**Elm Tree House
Church Lane
Wendlebury
OX25 2PN**

19/01006/LB

Proposal: Internal and external alterations to the house and garage

DRAWING TITLE
Proposed house elevations

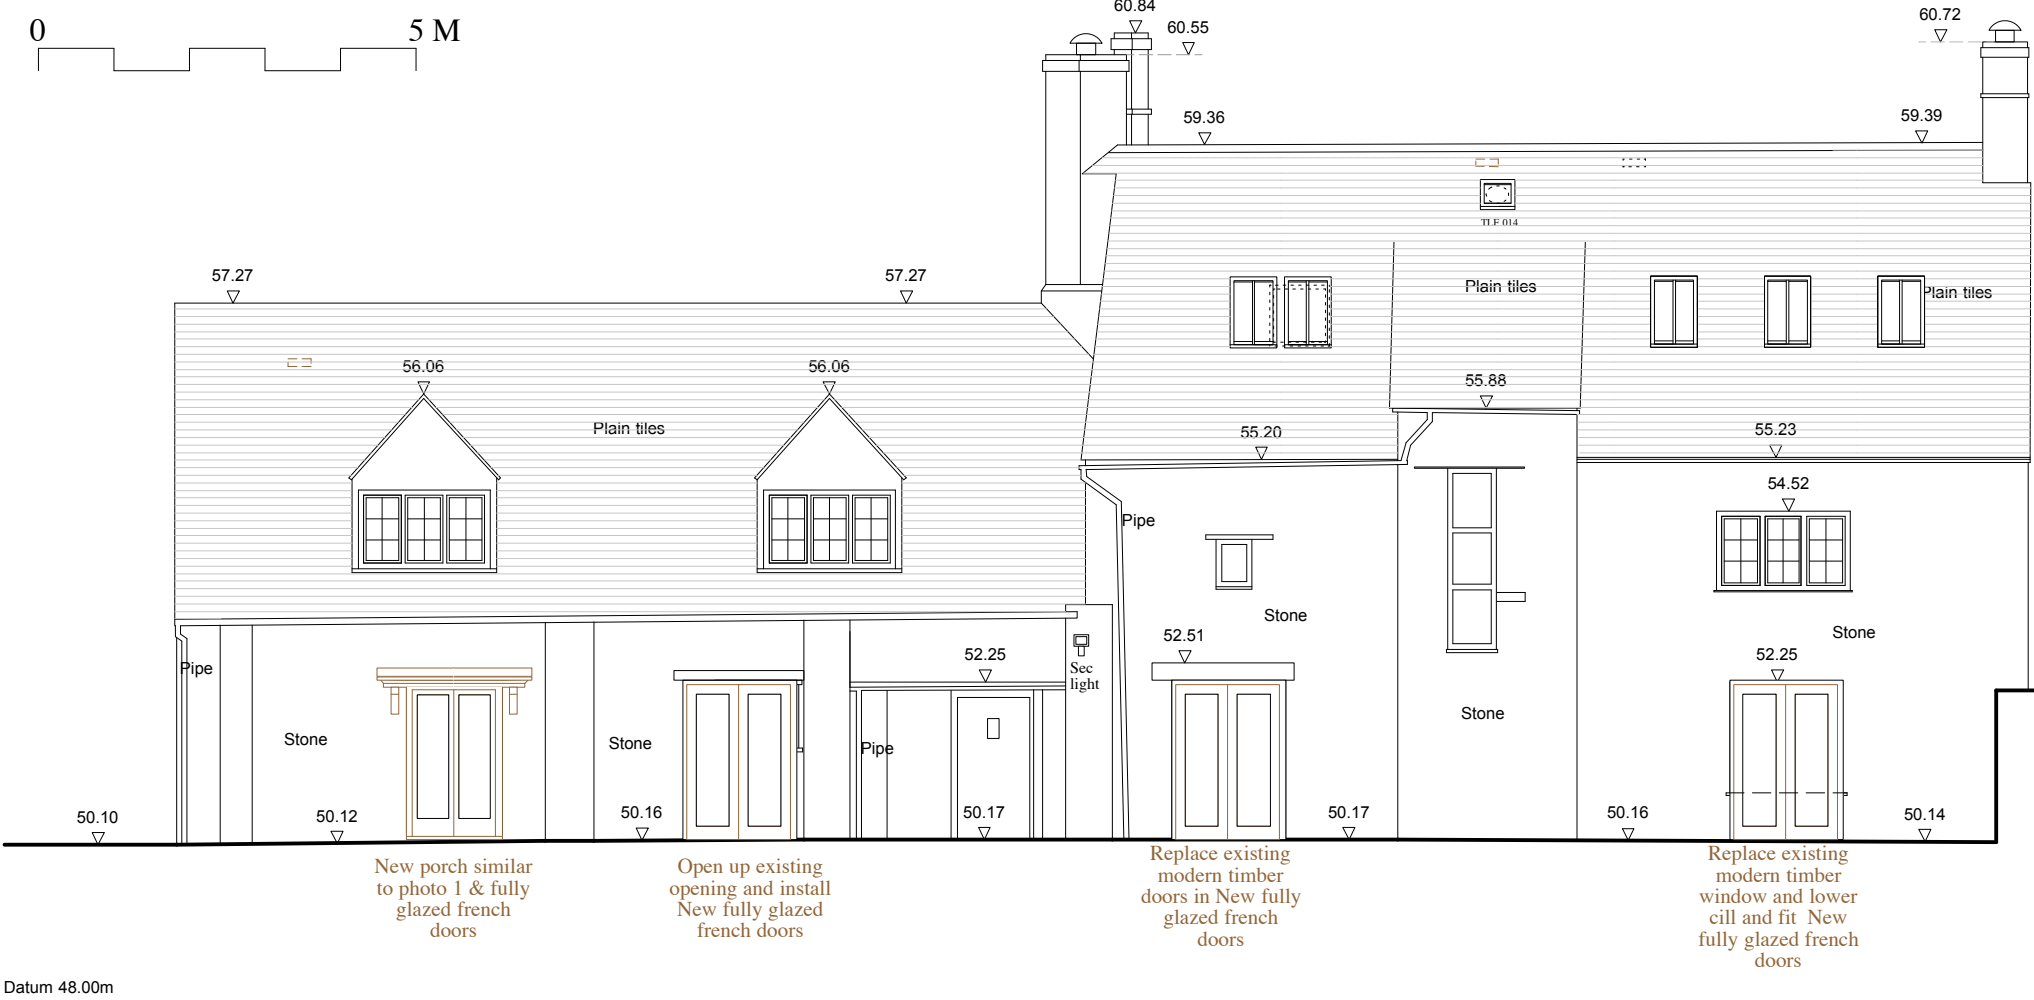
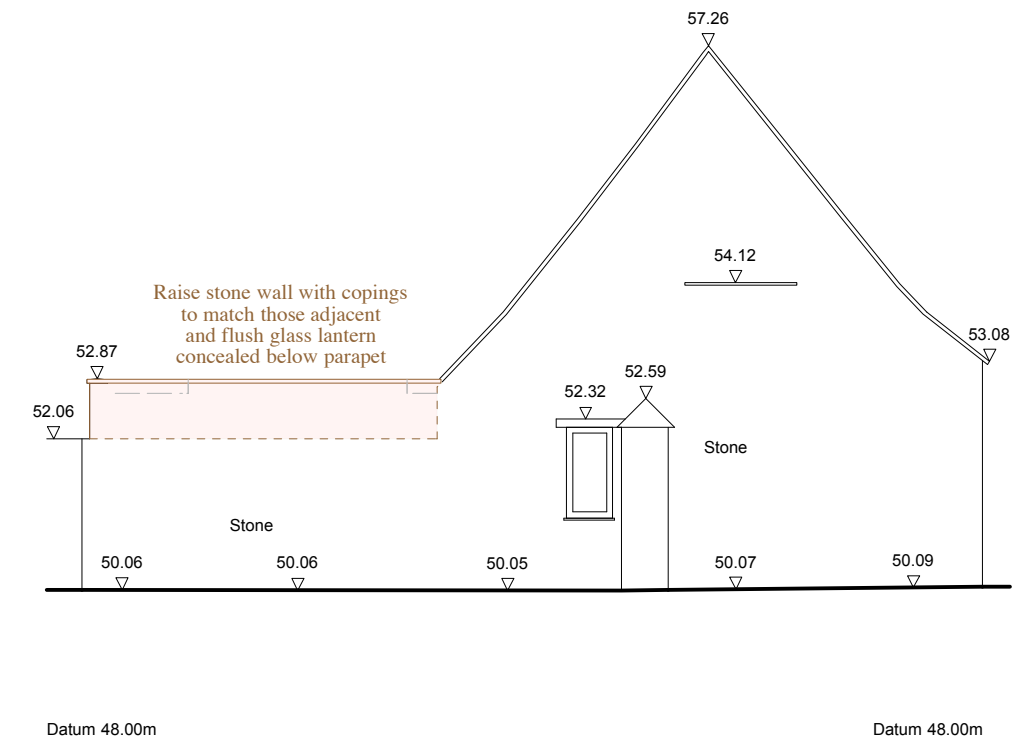
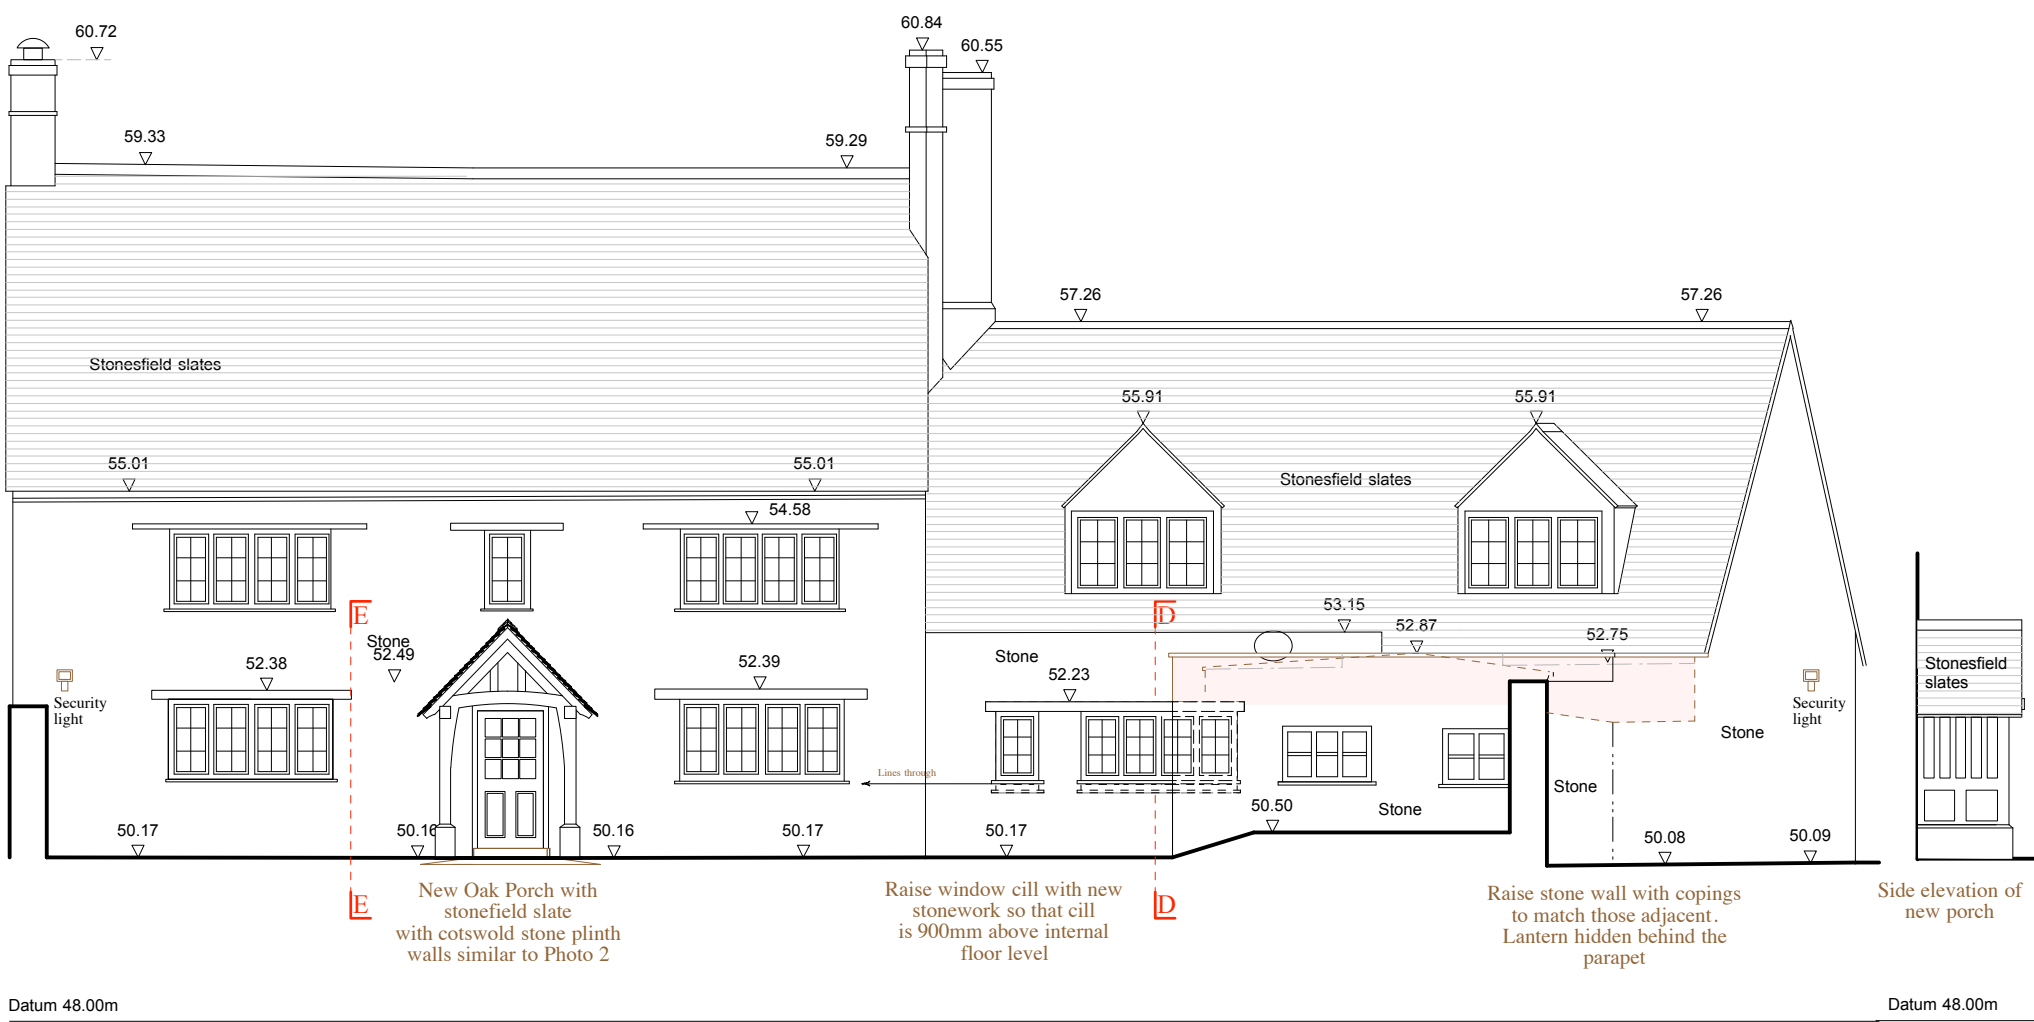
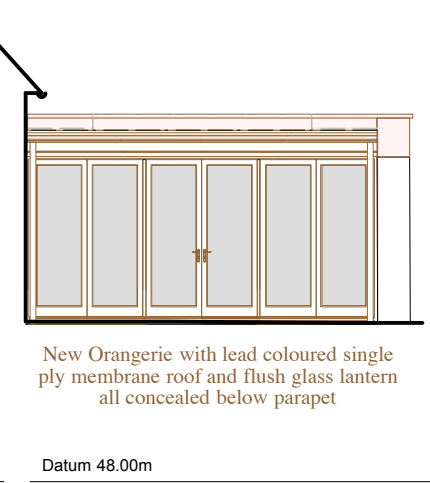
- 8.6. The proposal also includes alterations to a number of windows to provide doors, which would result in the need to widen the existing openings. There is, however, evidence that these openings have been altered previously and the Conservation Officer therefore advises that this would not cause further harm the significance of the listed building.

- 8.7. A timber canopy porch is proposed to the front of the building, which would be located above the main entrance door. Photographic evidence shows a similar canopy was previously erected in this location. The Conservation Officer considers that the installation of a canopy would not cause harm to the fabric of the building and that its design would complement that character of the house.

- 8.8. The proposals also include the alteration of the existing utility area to create a garden room. Concerns were raised about the visual appearance of this due to the roof lantern that would be visible above the proposed parapet. Amended plans have been received that now include a flat roof lantern which would not be visible. This is welcomed as it is considered that it would maintain the appearance of the building from the important front elevation, as well as ensuring the proposal does not harm the character of the surrounding area due to its prominence in the street scene. Most of the fabric to be removed in this area of the building is modern fabric. However, there is one internal wall to be removed that is believed to be a historic wall to a pigsty that was located here historically. This wall although historic fabric is not considered to contribute to the significance of the building and therefore on balance its removal is considered acceptable.
